From: publicaccess@cherwell-dc.gov.uk <publicaccess@cherwell-dc.gov.uk>
Sent: 08 July 2019 20:12
To: Public Access DC Comments <PublicAccessDC.Comments@Cherwell-DC.gov.uk>
Subject: Comments for Planning Application 19/01036/F

Address: Bicester Eco Town Exemplar Site Phase 2 Charlotte Avenue Bicester

Proposal: Development of a new Local Centre comprising Retail, Commercial and Community floorspace (flexible Use Class A1/A2/A3/B1/D1), and 38 residential units (use class C3) with associated access, servicing, landscaping and parking

1 West Elevation - River Corridor
1 : 200

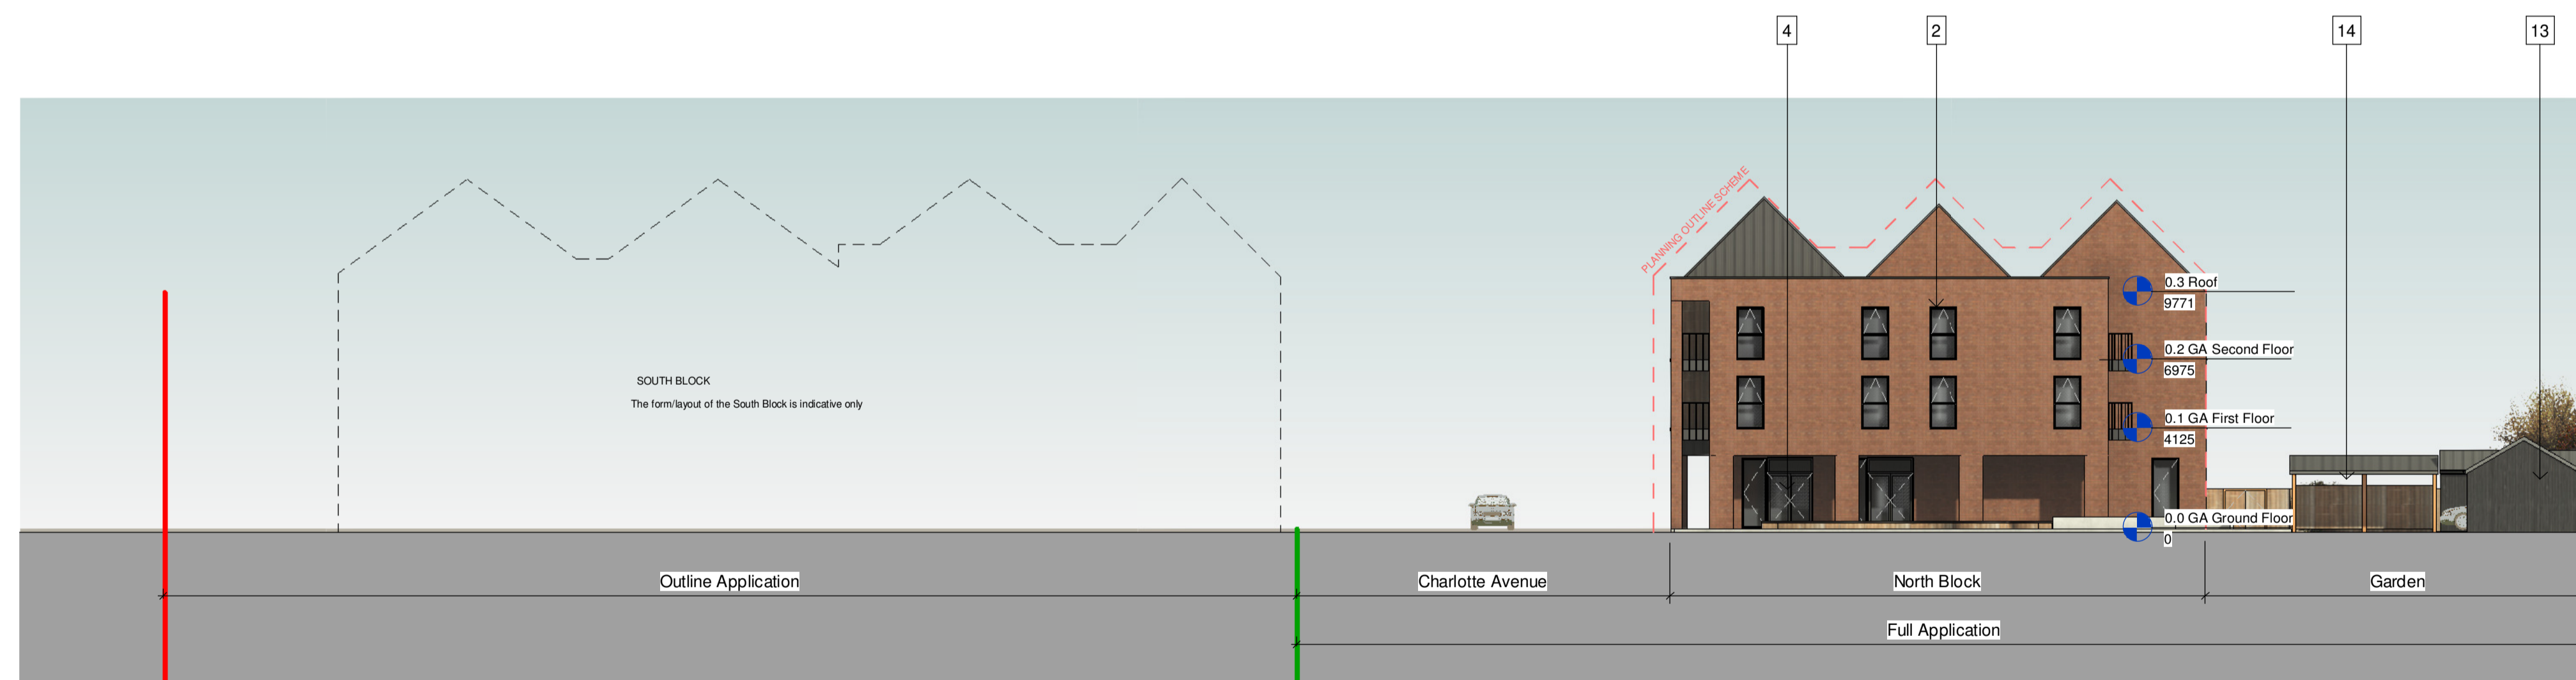
The applicant proposes building a large number of flats, each with a balcony, overlooking the river corridor. These balconies will face existing homes, including my own, on the opposite side of the river corridor; as well as overlooking a children's play area.

This is already a very noisy area. The acoustics of the river corridor are such that even normal sound levels echo and are magnified, so that sound is clearly heard within the adjacent homes. The addition of 14 new balconies overlooking the area can only exacerbate this problem. Even just normal use of the balconies will, due to the acoustics of the area, lead to unacceptable levels of noise for the adjacent properties, especially at night.
